**Response to Planning application from Hertfordshire County Council (T and CP GDP Order 2015)**

District ref: 6/2021/0314/FULL  
HCC ref: WH/5717/2021  
HCC received: 6 May 2021  
Area manager: Matthew Armstrong  
Case officer: Paul Marshall

22 CHURCH LANE NORTHAW POTTERS BAR EN6 4NX

AMENDED PROPOPSAL  
Erection of a 5 bedroom detached house

| Drawing No. | 2019/1327/4 |

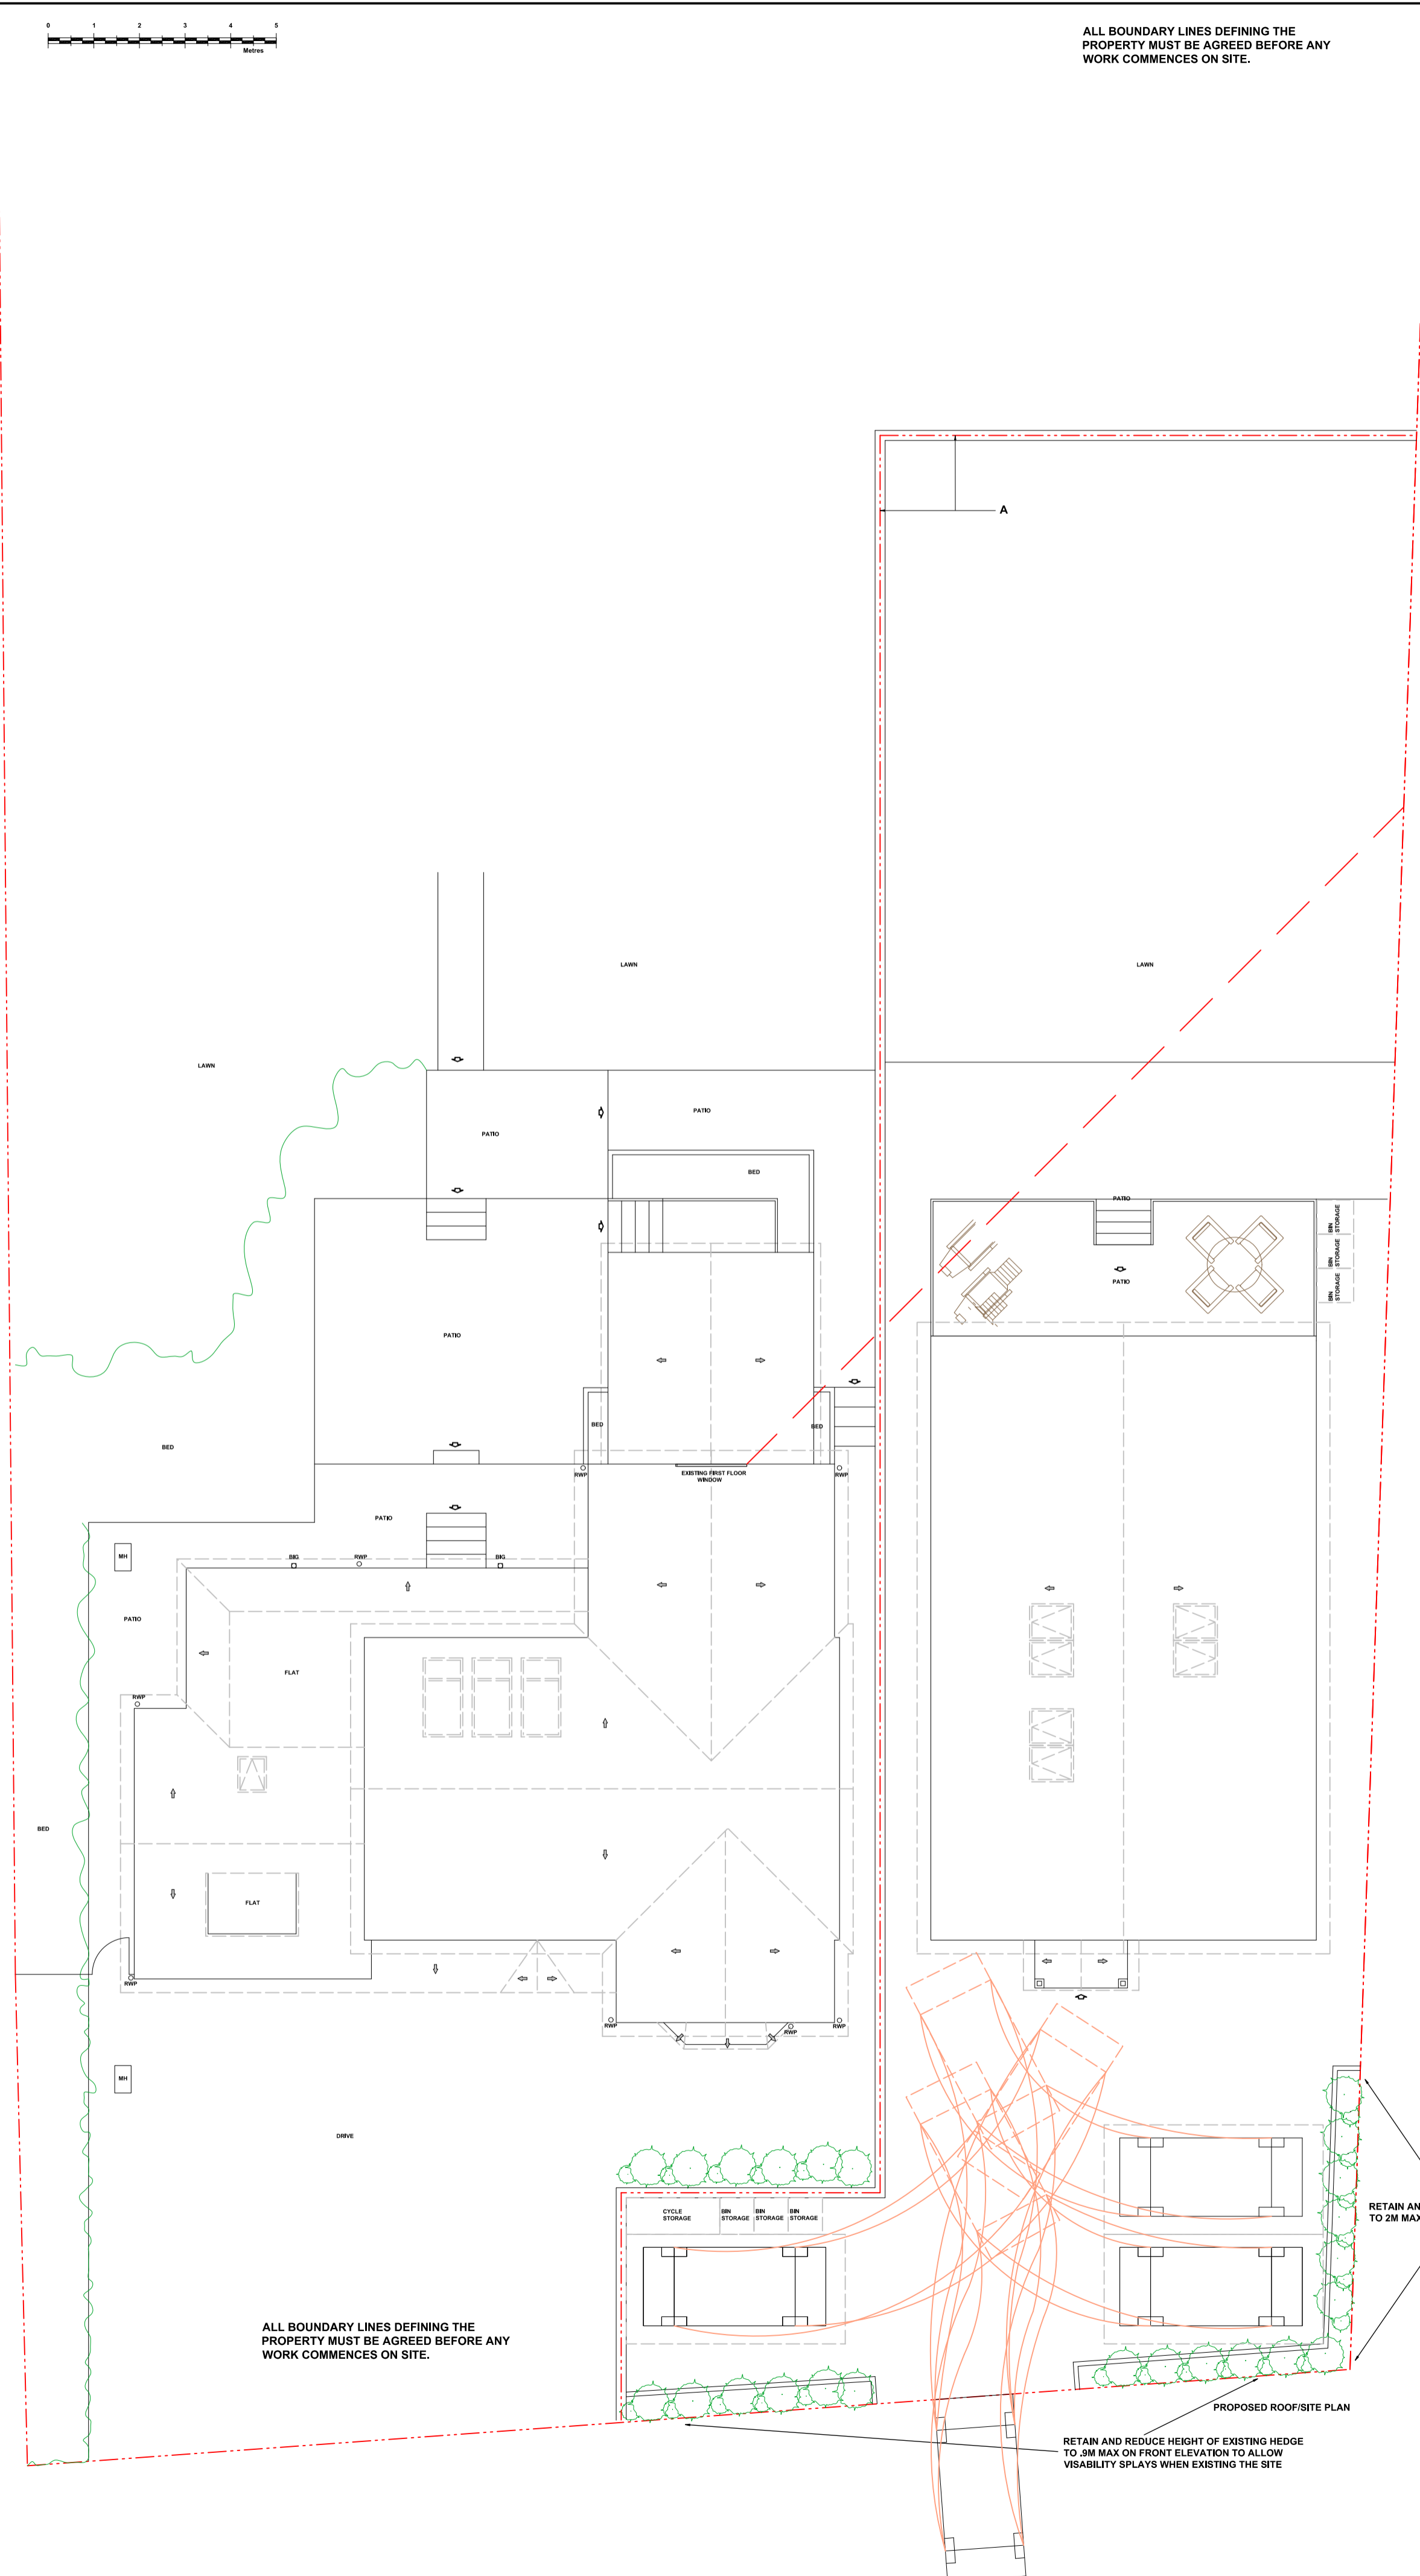
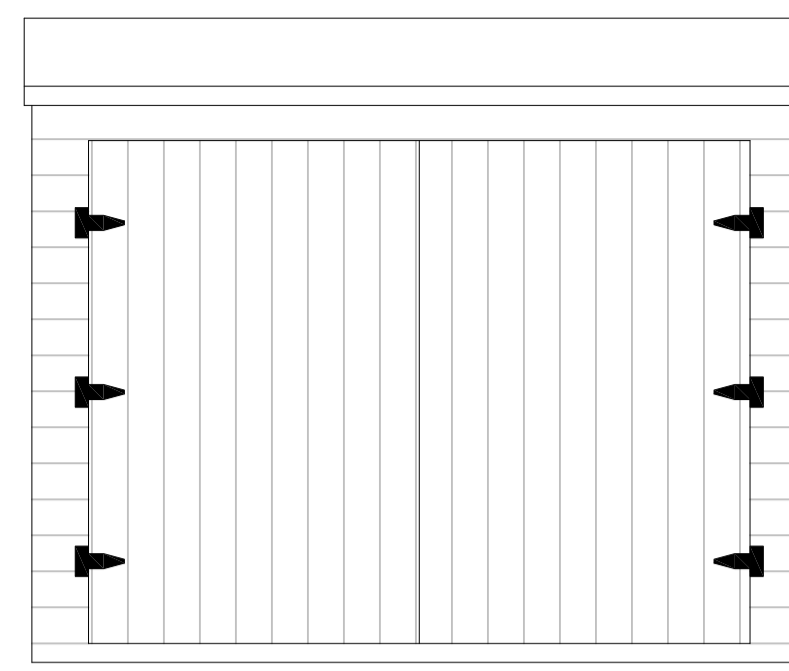
The submitted tracking drawing has met the requirement of 4.571m vehicle length. However, Church Lane is narrow with vegetation intruding. The accuracy of ordinance survey maps has a degree of accuracy of up to 2m. Considering the narrowness of Church Lane, I would want to see a more accurate drawing.

I must again point out the access as shown on drawing 2019/1327/4 at 6.729m is a sub-standard access which we would not build. The maximum width of a domestic vehicle access / vehicle cross over is 5.4m as discussed above.

As was previously asked for a detailed vehicle crossover drawing showing a visibility splay has not been provided.

The visibility splay must be measured from the back edge of the carriageway (centre of proposed crossover) a minimum of 2m (x distance). Manual for Streets 7.7.6 states: (reasonably built up areas) X distance should be 2.4m in most built up areas can be reduced to 2m in some very lightly trafficked and slow-speed situations.
